From: Finlay Gardner
Sent: 04 September 2019 16:17
To: Planning.Responses <Planning.Responses@arun.gov.uk>
Subject: FW: Application BR/178/19/PL

I have recently taken over your application BR/178/19/PL (Delawarr House, Flat 1). I am emailing with a few questions about the proposed plans. In the larger flat the bedroom appears to not have any direct access to daylight. Would there be a possibility of a window in the dressing room? Any information you can give me will be greatly appreciated.

PROPOSED FIRST FLOOR PLAN/ROOF PLAN
Scale 1:50

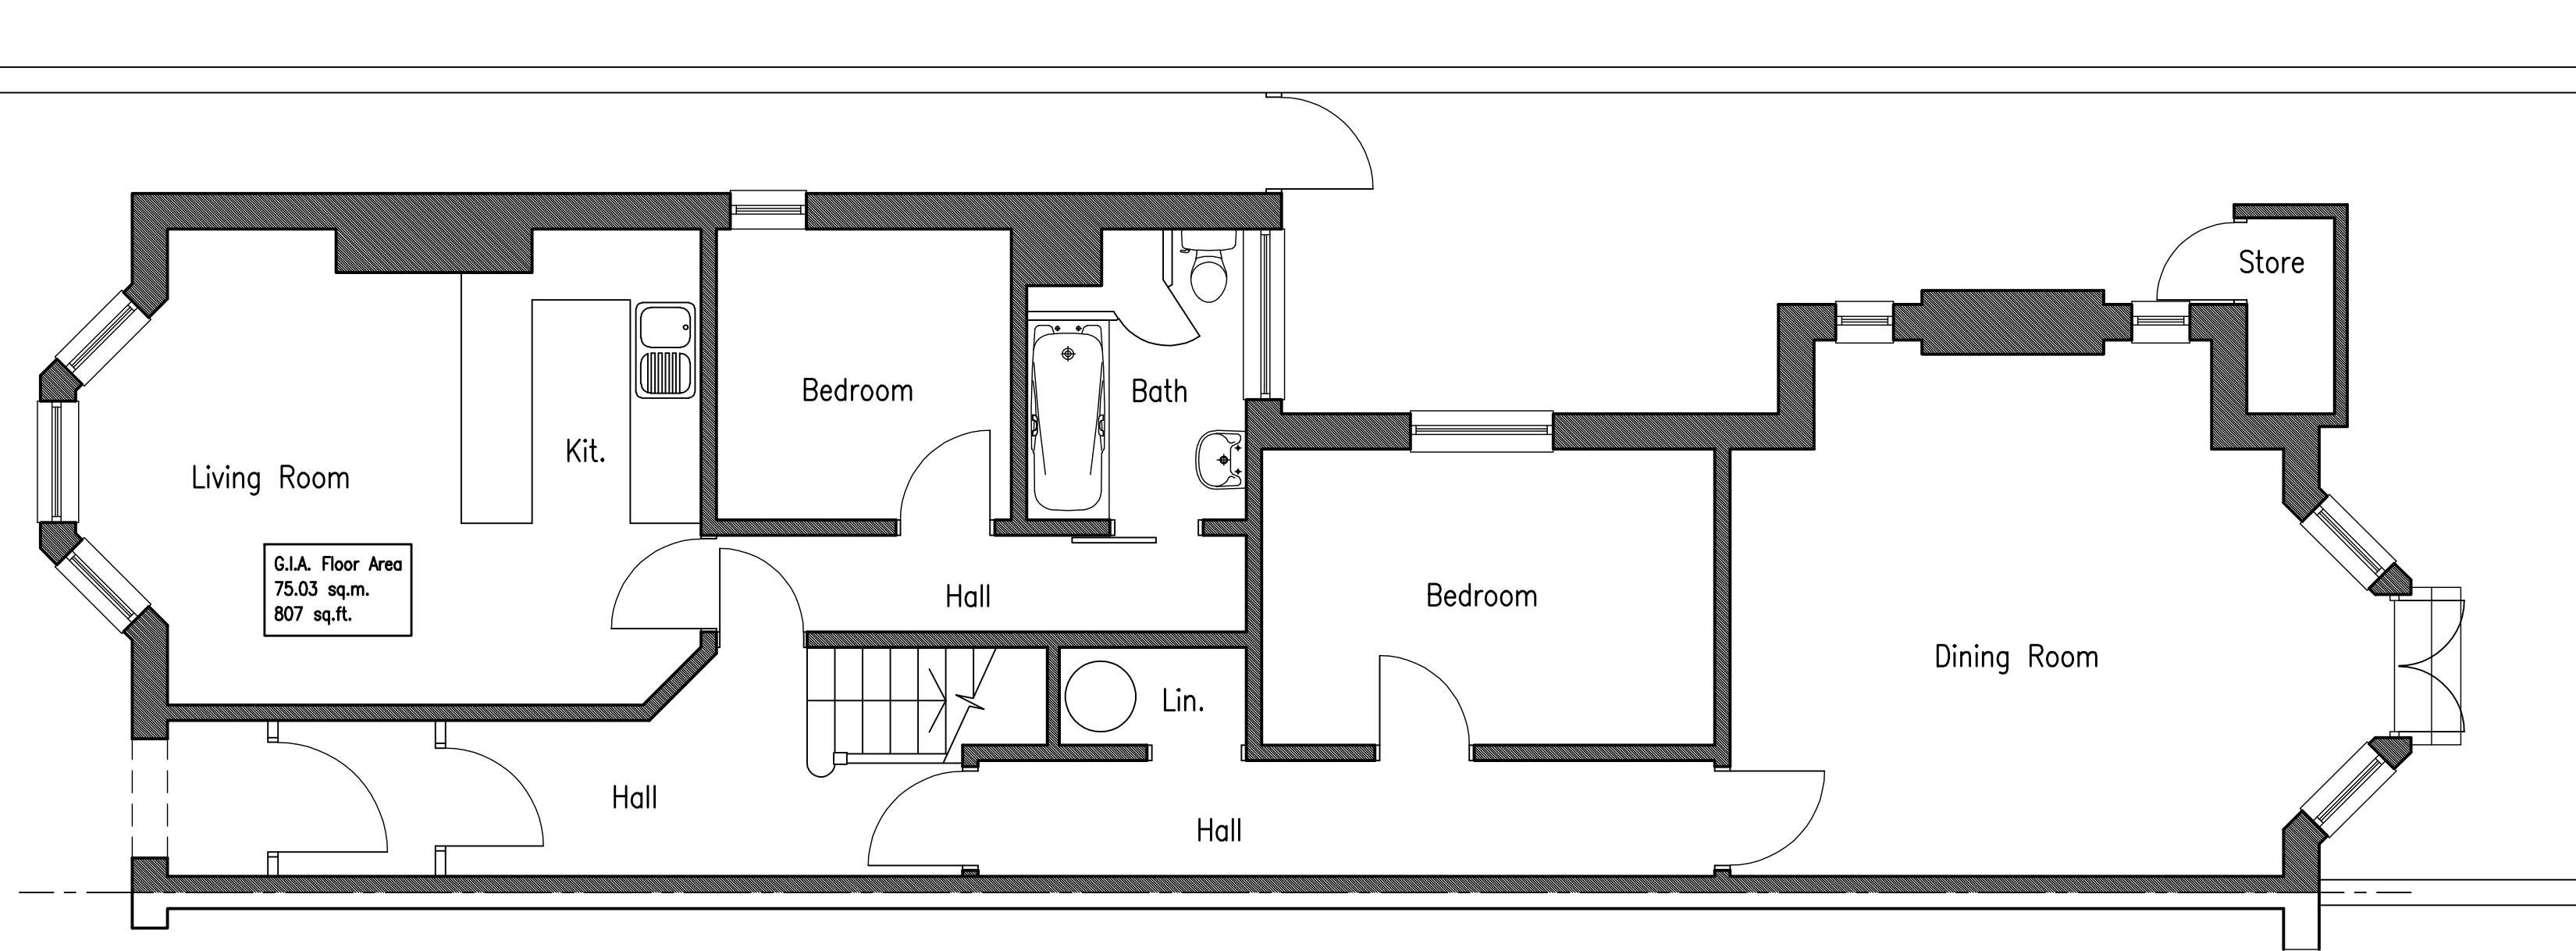
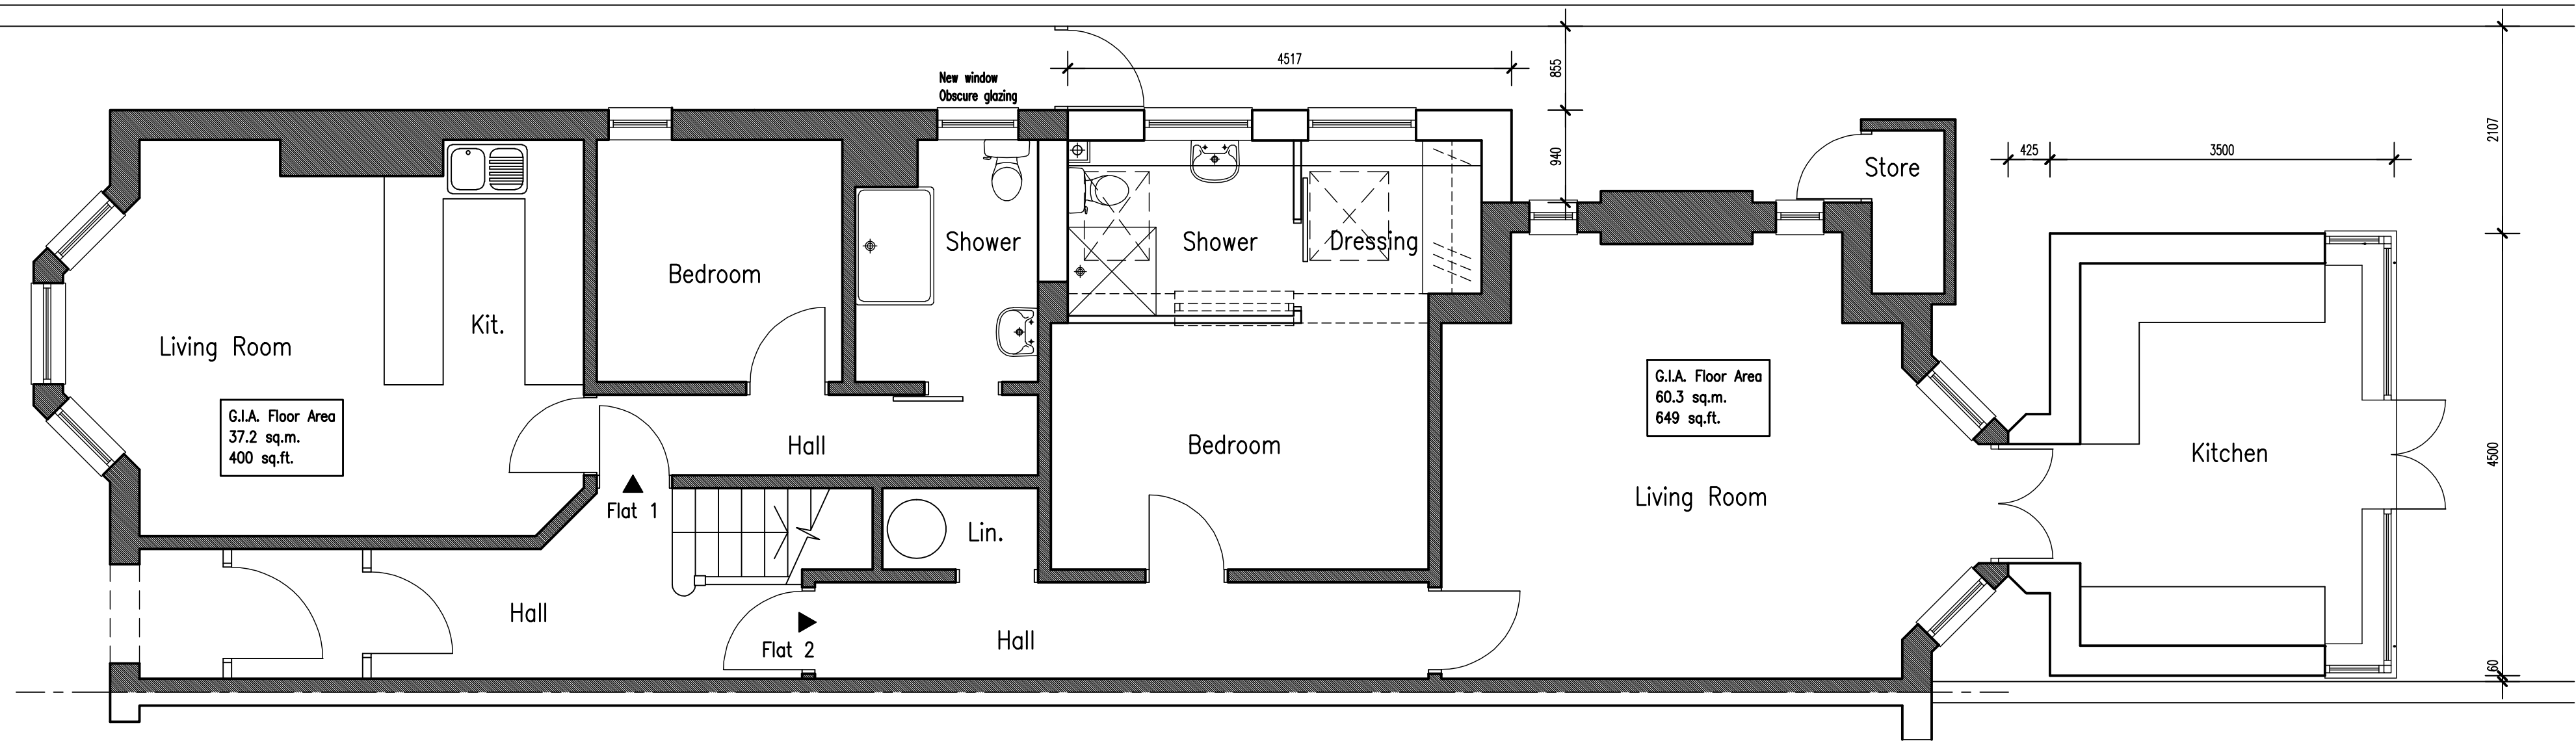
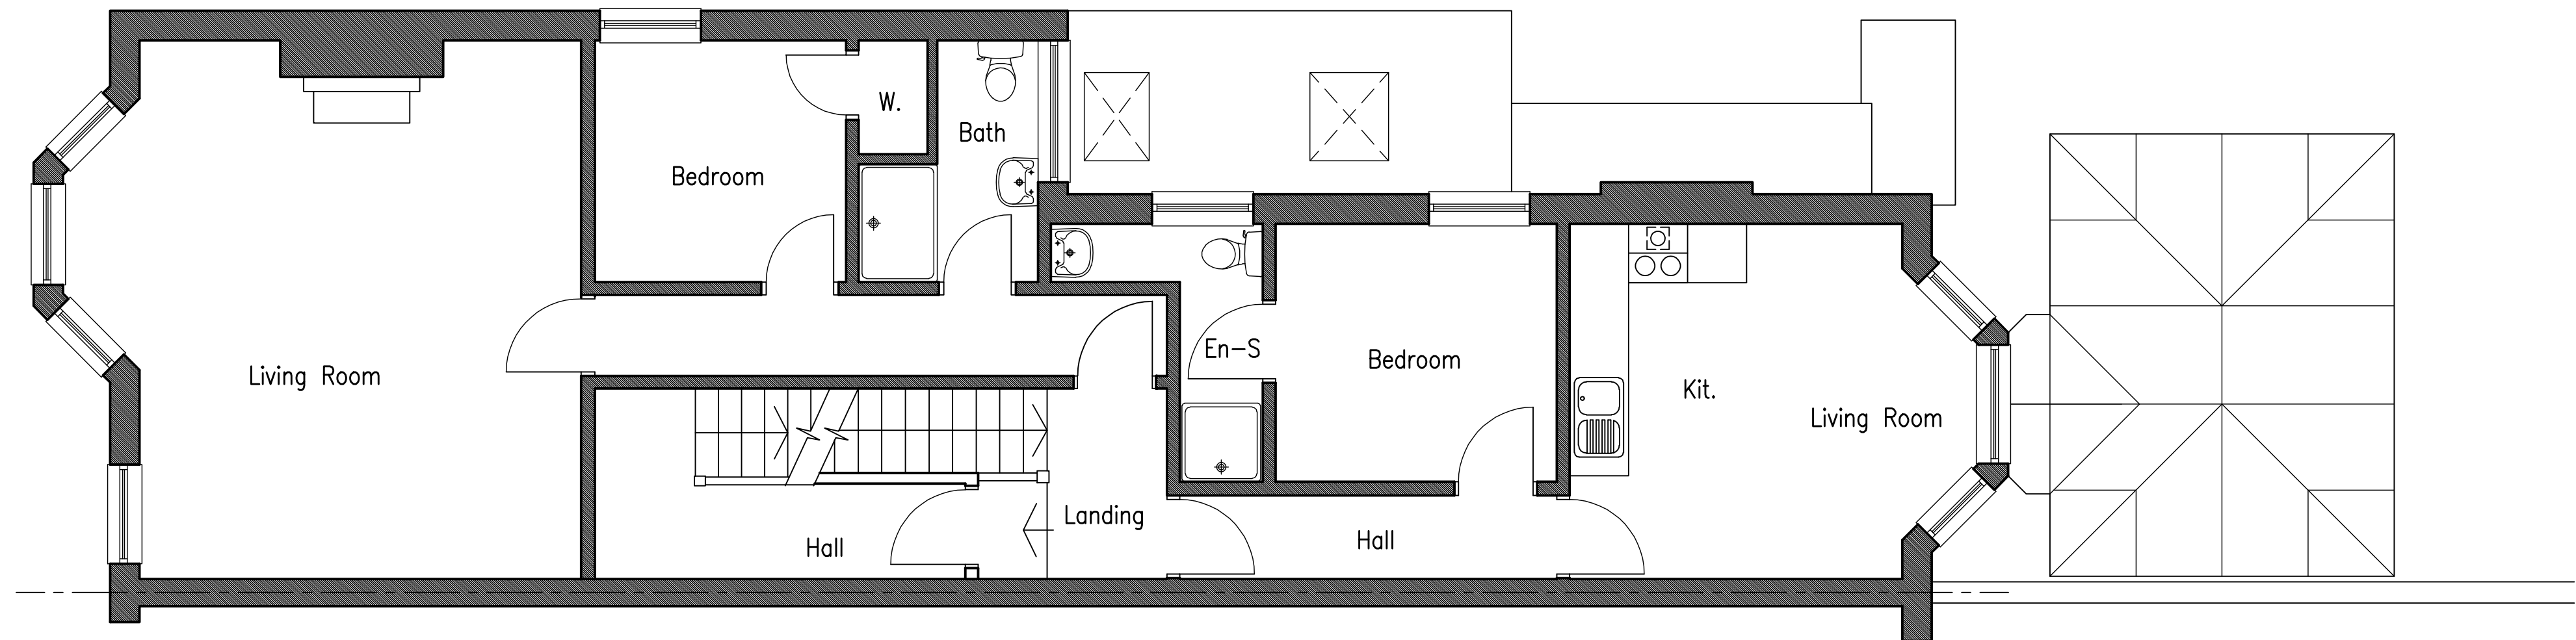
The issue that we find with the sky light is that it is not direct light into the bedroom, the way we would see to overcome this is to have a window in the dressing room, is this a possibility?

Further to your earlier e-mail please find attached amended planning drawings showing an additional window to the side extension bedroom as requested.
